## **Objection to Proposed Development**

Budawang School for Specific Purposes

SSD-8845345

17 Croobyar Rd Milton

4 HYDROTHERAPY SOUTH ELEVATION.  
1:100

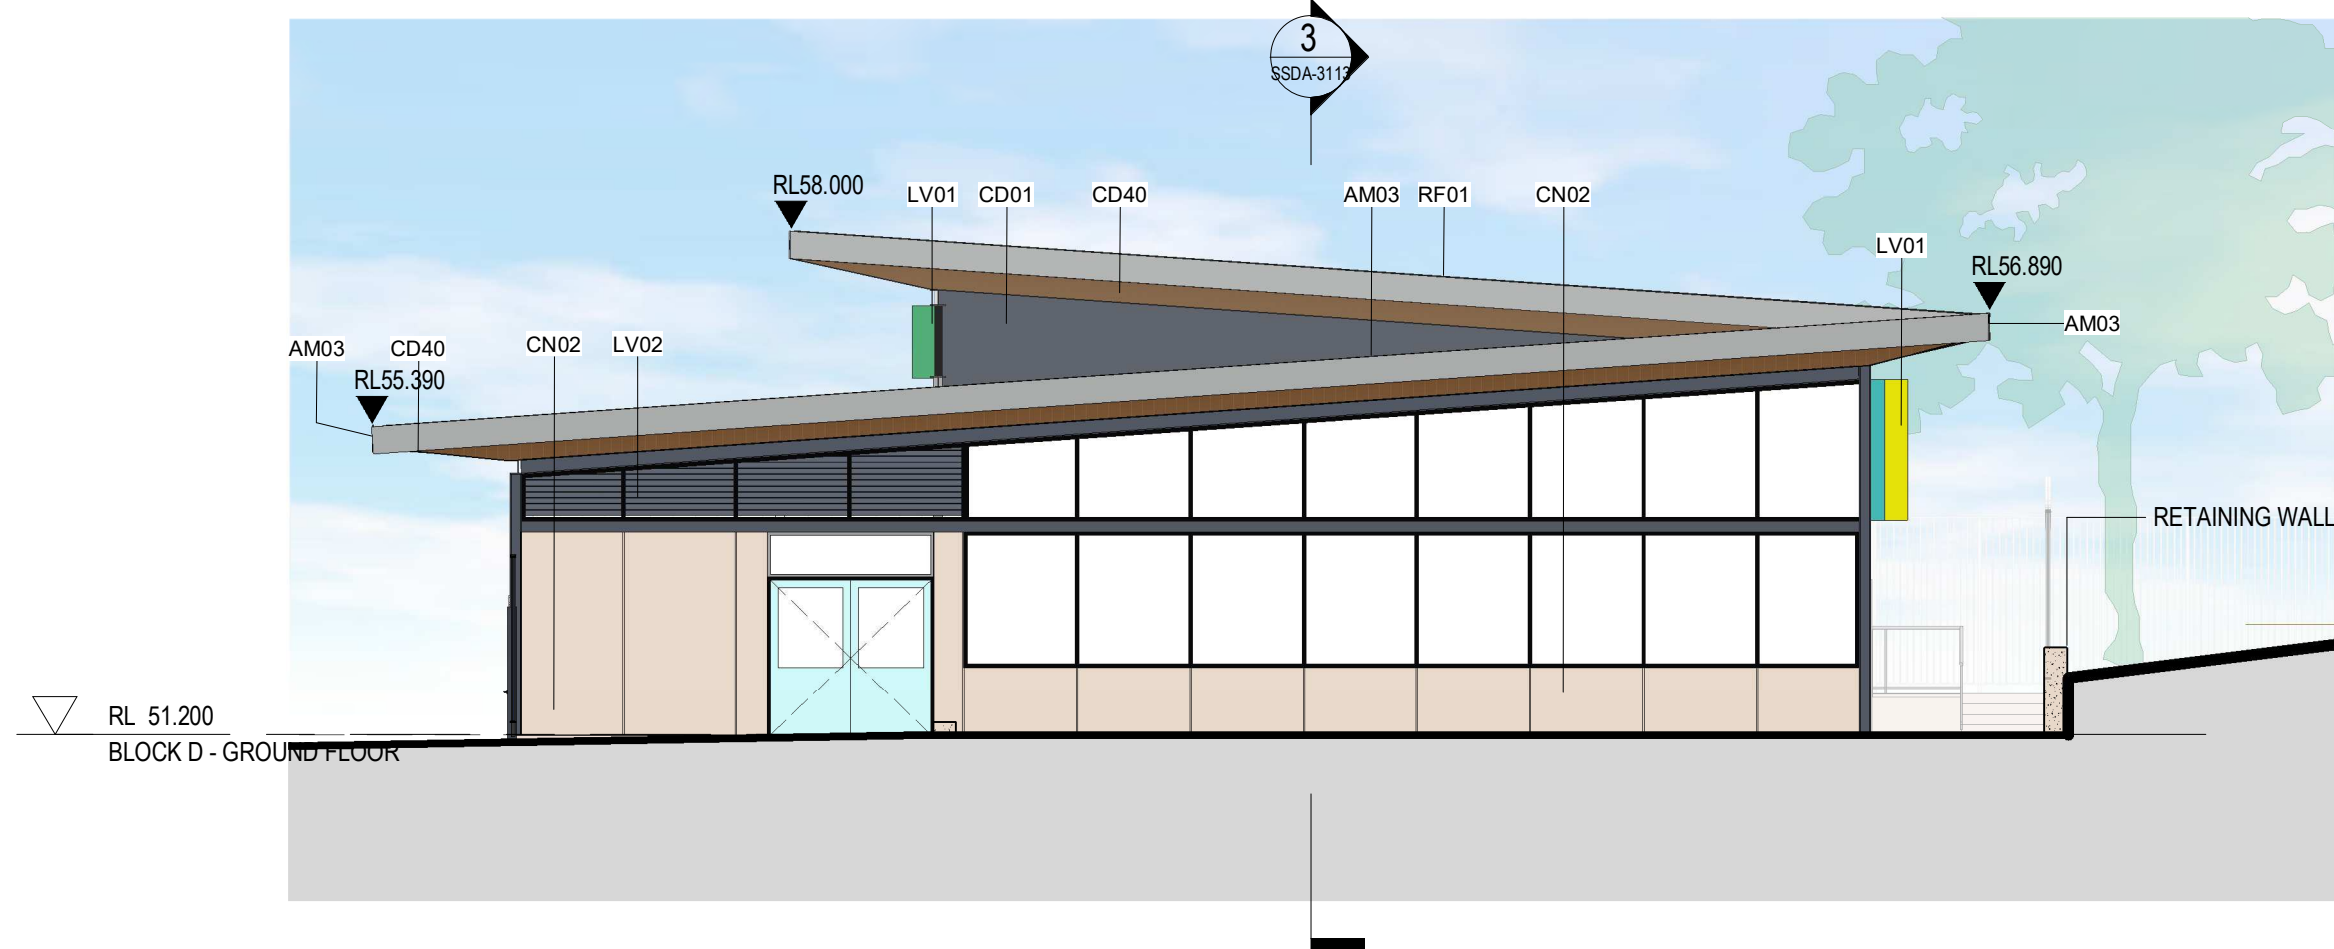
The overdevelopment of this site means that the proposed Hydrotherapy Pool building is sited only 3m from the Croobyar Rd (northern) boundary, with its roofline only 2m from the boundary. All residential development on Croobyar Rd must comply with a minimum 6m setback. Given the bulk and scale of this building presenting to Croobyar Rd, this building setback must be increased to at least 6m.

The bulk and siting of the proposed hydrotherapy pool will also have unacceptable visual impact on the nearby 'Heritage Bakery', a 150 year-old stone building that is the oldest continually occupied commercial building in the Shoalhaven. The impact on the Bakery is said to be mitigated by the 'retention' of trees between the pool and the Bakery. But these trees are on the Heritage Bakery's land, not DoE land. This means the proposed plan requires the Heritage Bakery owners to provide their own mitigation of the impact of the bulk and scale of the hydrotherapy pool building, when the BSSP design should include its own planting and screening to do that.
